Our ref: DOC21/26870
Senders ref: SSD 10425

Response to Submissions – Tallawong Station Precinct South – Stage 2 Detailed Design Modification Application 1 (SSD 10425)

FIGURE D3 FLOOD LEVEL DIFFERENCE – 5% AEP

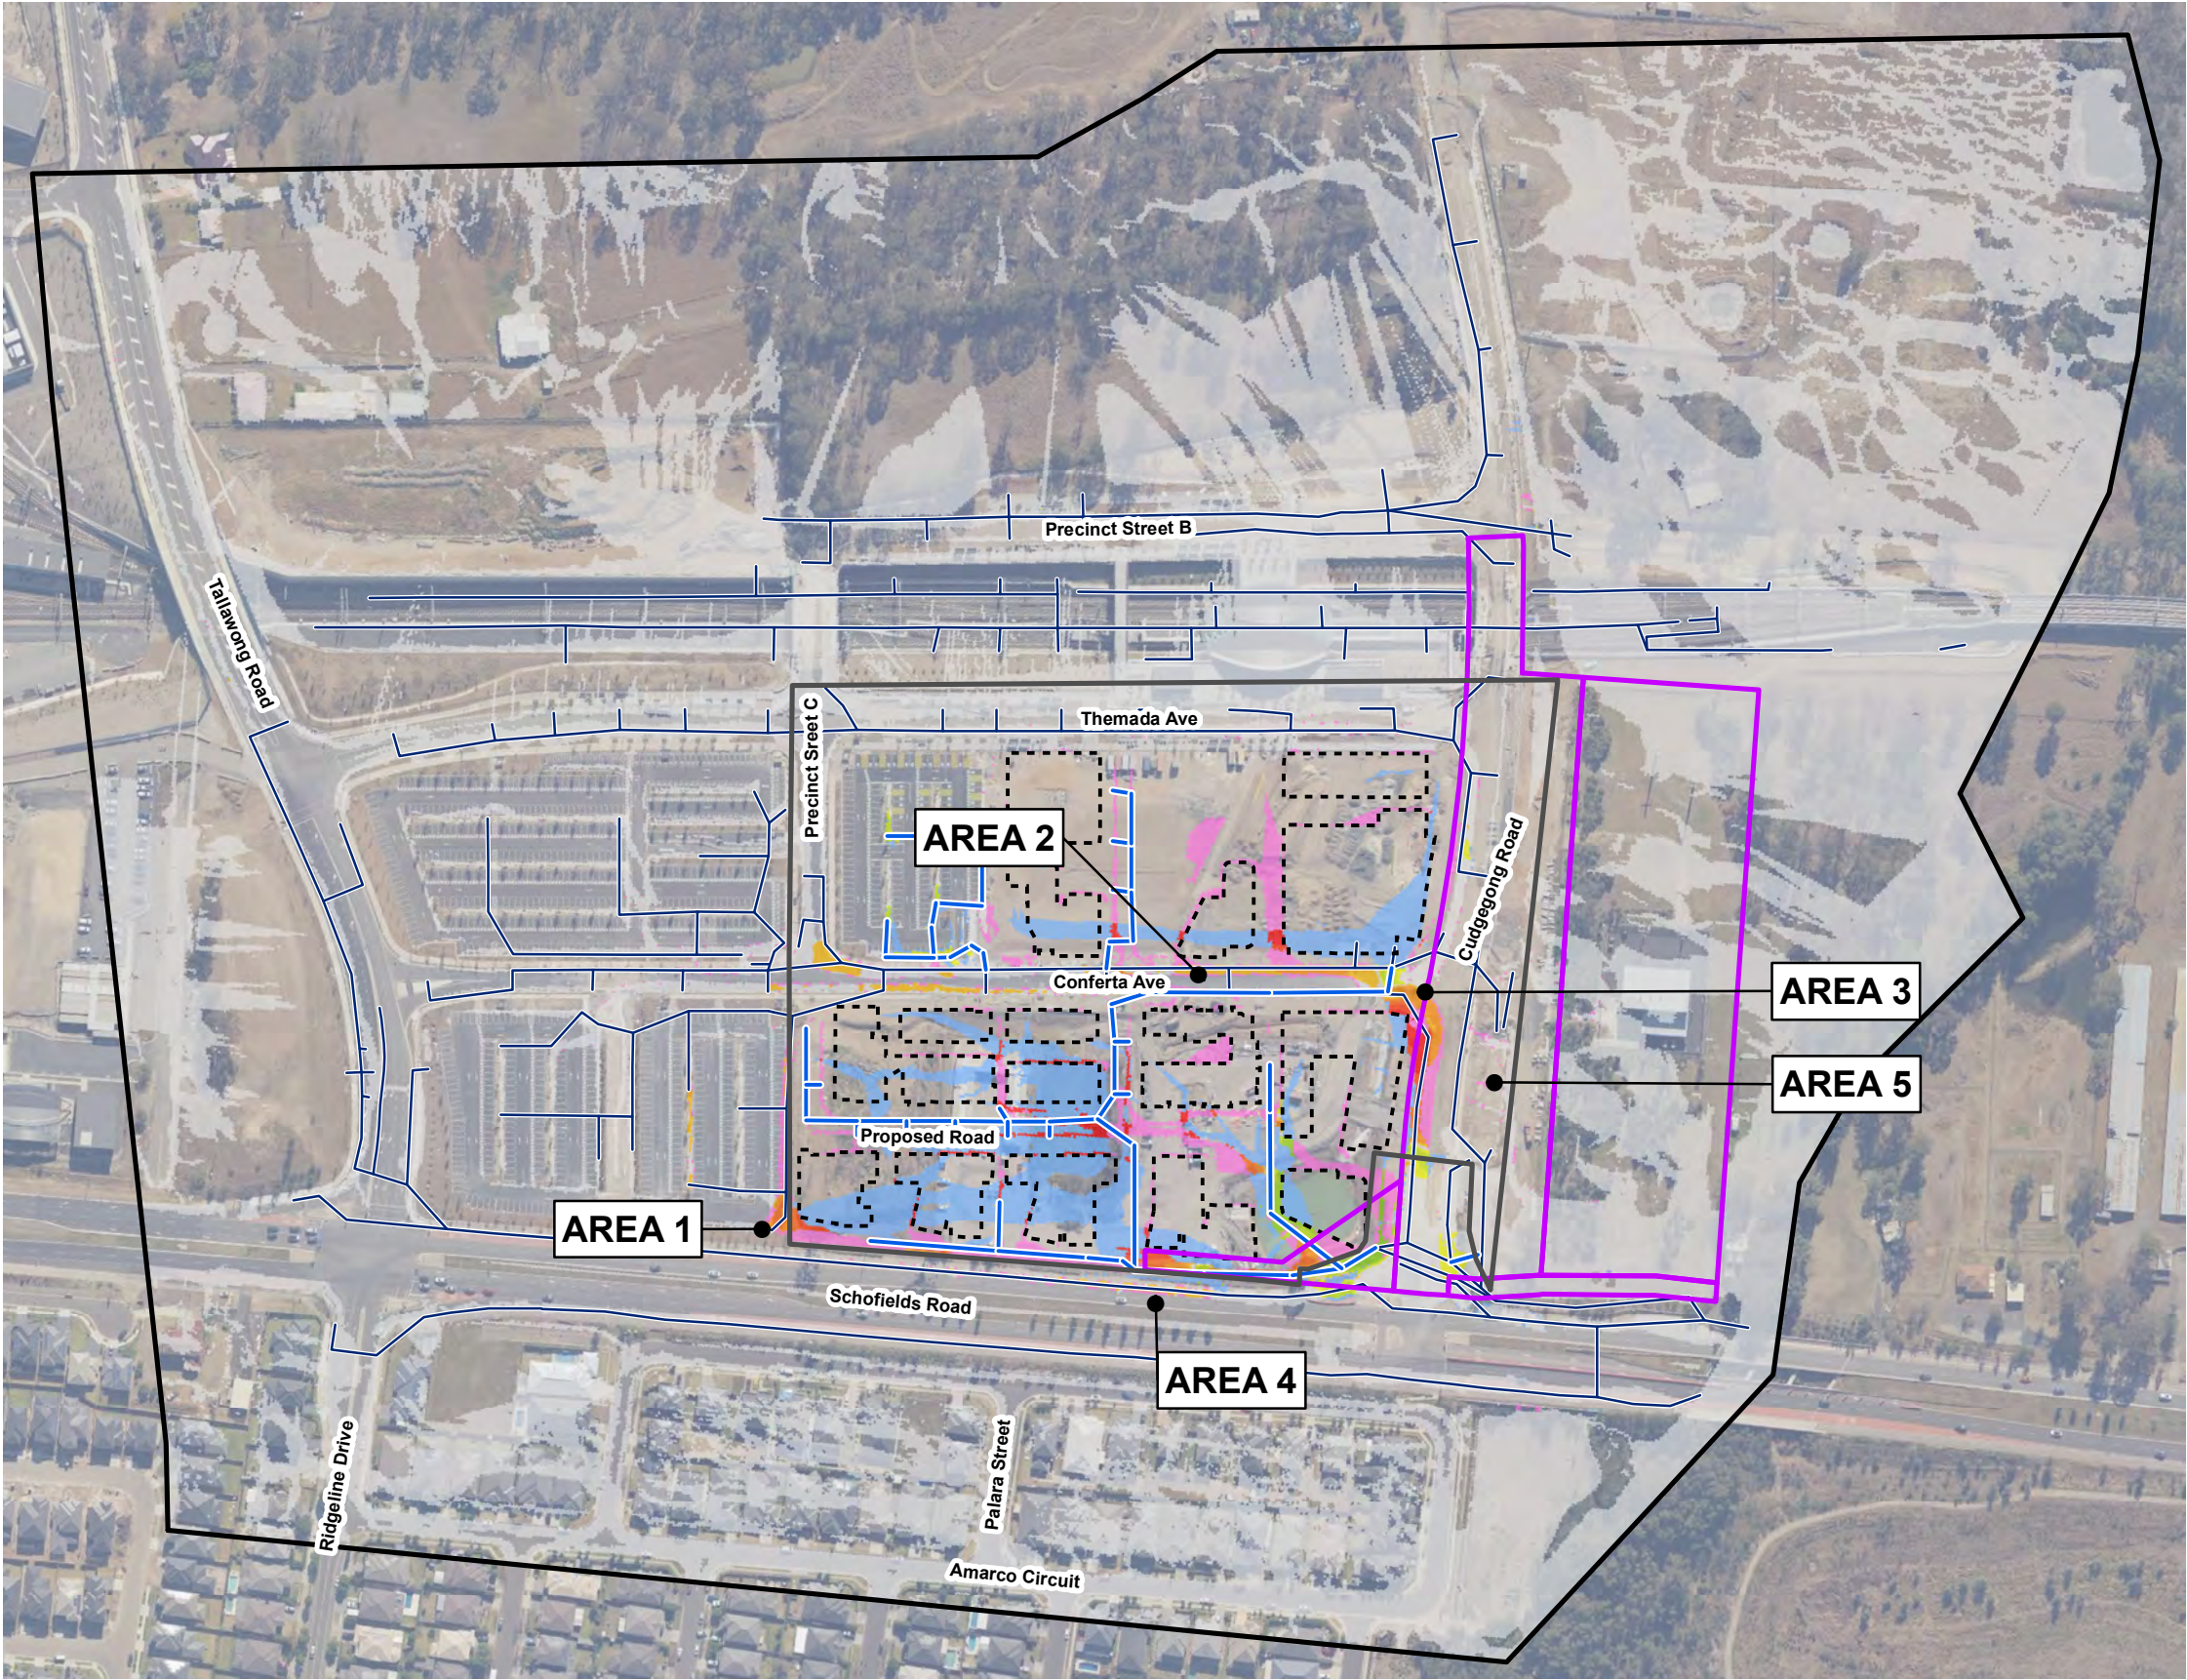
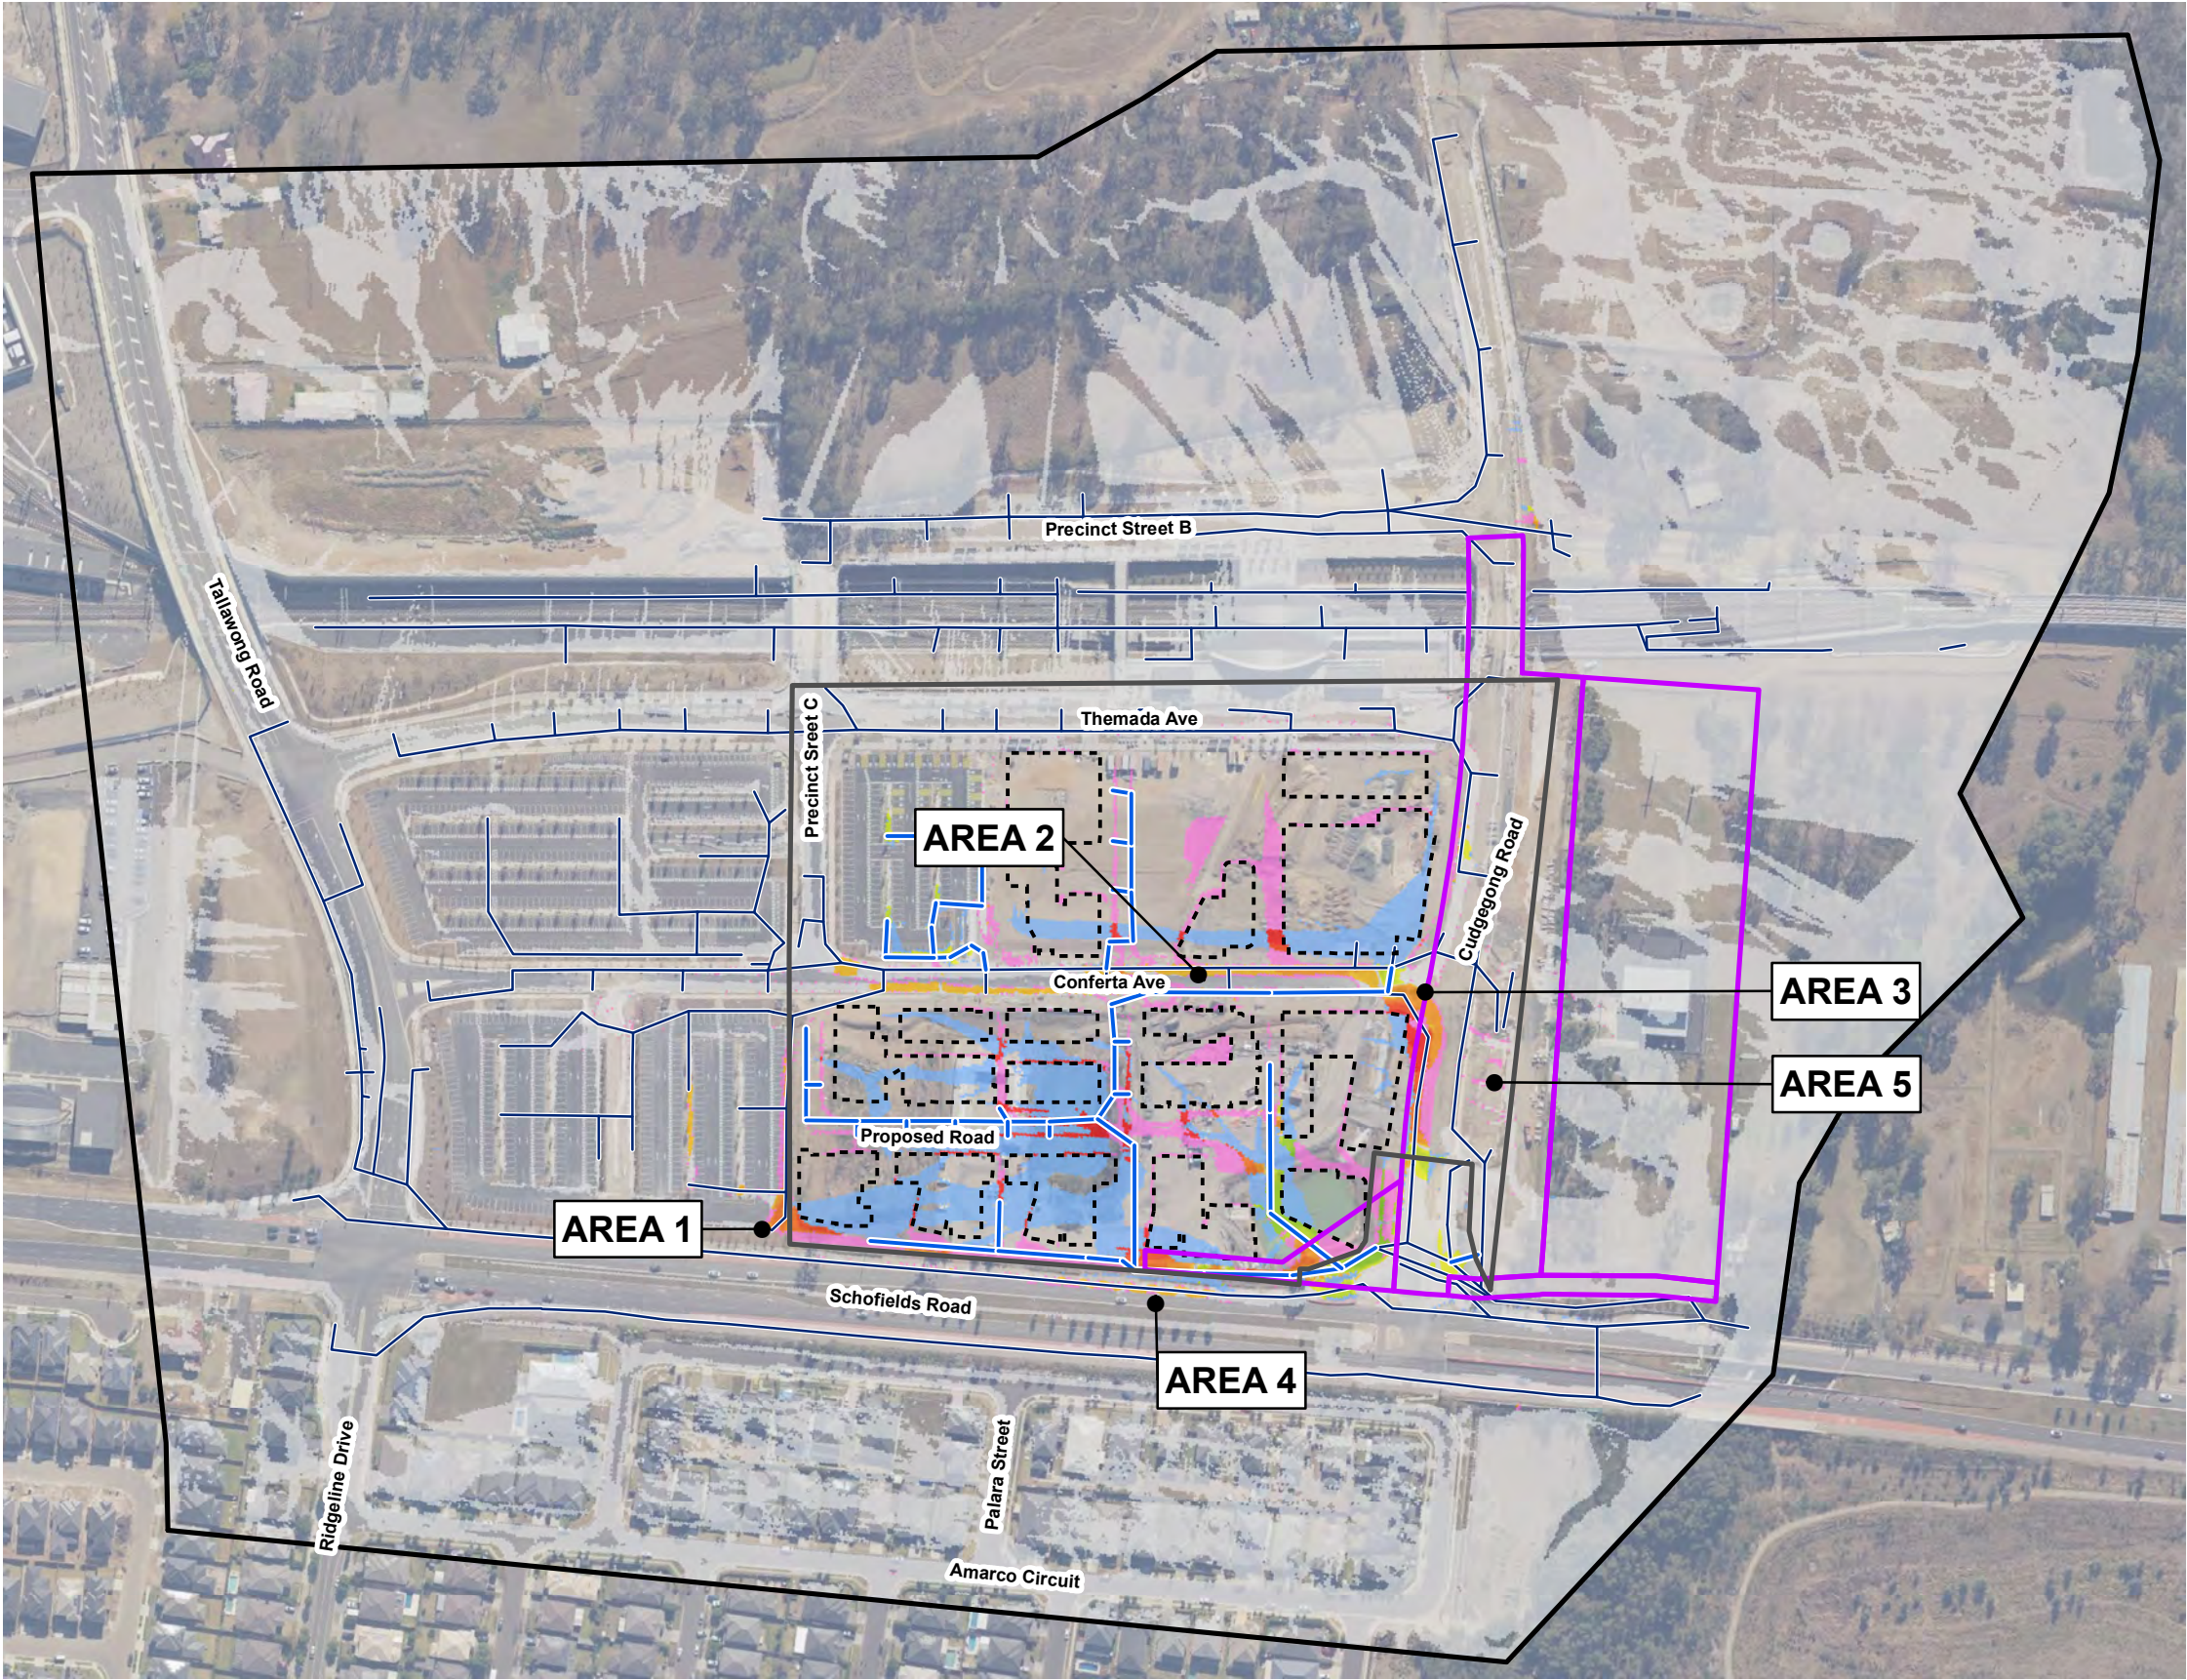
- The flood level difference maps need careful review as they show some discrepancies particularly at the southern corner of Cudgegong Road. The difference maps show reduction instead of increase in levels at this area for all flood events.
